**WEST SUSSEX COUNTY COUNCIL
INFRASTRUCTURE CONSULTATION**

SUBJECT: A/78/09- Terrace of 4 x 2-bed houses (resubmission following A/75/08)

Land to rear of, 7-15 Lansdowne Way, 101, Lloyd Goring Close, Angmering, West Sussex

LAYOUT PLAN 1/200

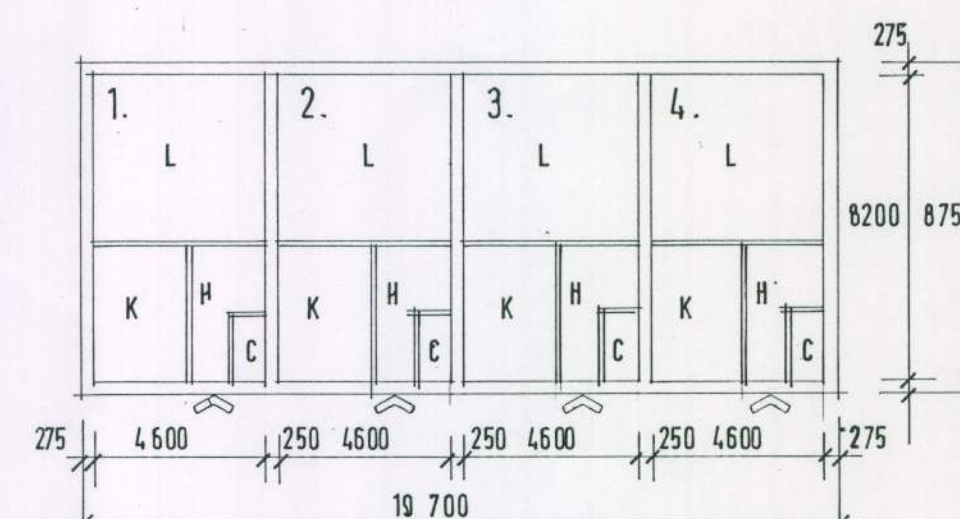
There do not appear to be any proposed changes to the existing access onto Lloyd Goring Close. In terms of parking I can confirm that the proposed level of parking does not exceed the WSCC maximum parking standard. In terms of parking layout, an adequate area of hardstanding is shown to permit turning within the site. I believe this was an earlier concern on the previous application, however the properties locations have since been altered and therefore the situation appears to have been improved. Cycle parking has been proposed but will need to be increased to reflect the county's one cycle per bedroom policy.

The diagonal boundary on the application plan where the site entrance is marked should remain clear with no barrier or panel fencing so as to ensure there is clear visibility for both users of the footpath and those in vehicles.

If the LPA are minded to approve this application, a condition securing cycle parking (to ensure it is increased to one cycle per bedroom) and provision of car parking spaces prior to occupation of the dwellings should be included.
